14 October 2020

SSD 6965 - Barangaroo Building R4B (Mod 2) | Response to Submissions

## R4B SETOUT PLAN BASEMENT LEVEL B3

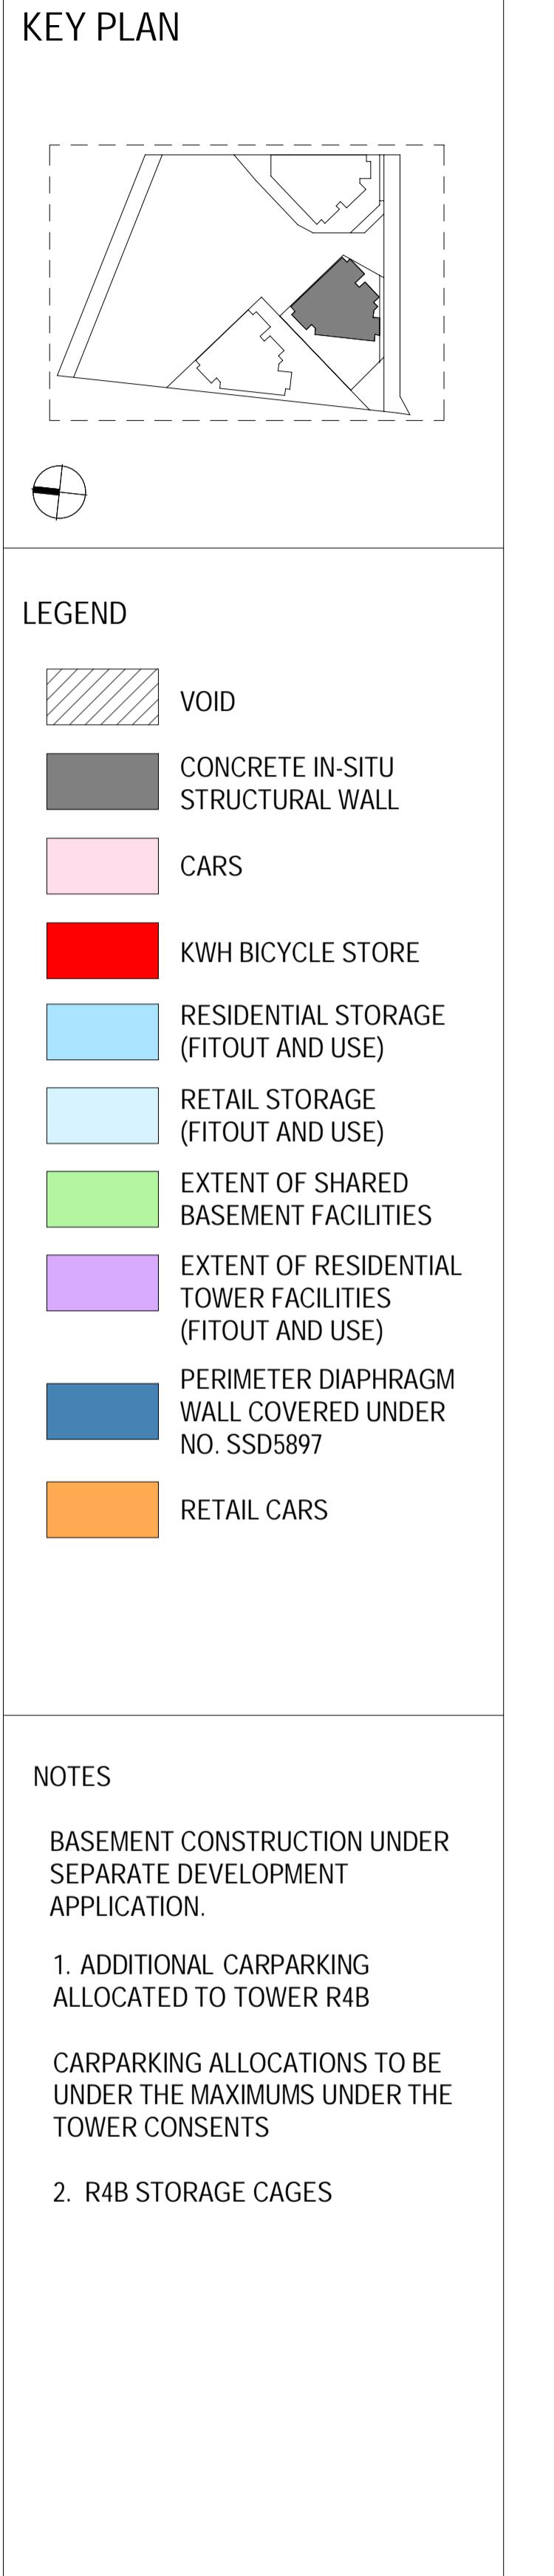
The City has reviewed the proposed modification to SSD 6965 and recommends that bicycle parking rates and storage areas reflect any amended dwelling mix. No further comments are provided.

It can be confirmed that the number of storage areas provided within the basement of the building for bicycle parking reflect the increased dwelling numbers for Building R4B. These storage areas are consistent with the requirements for 'Class 1' facilities outlined in Australian Standards for Off-Street bicycle parking AS2890.3.
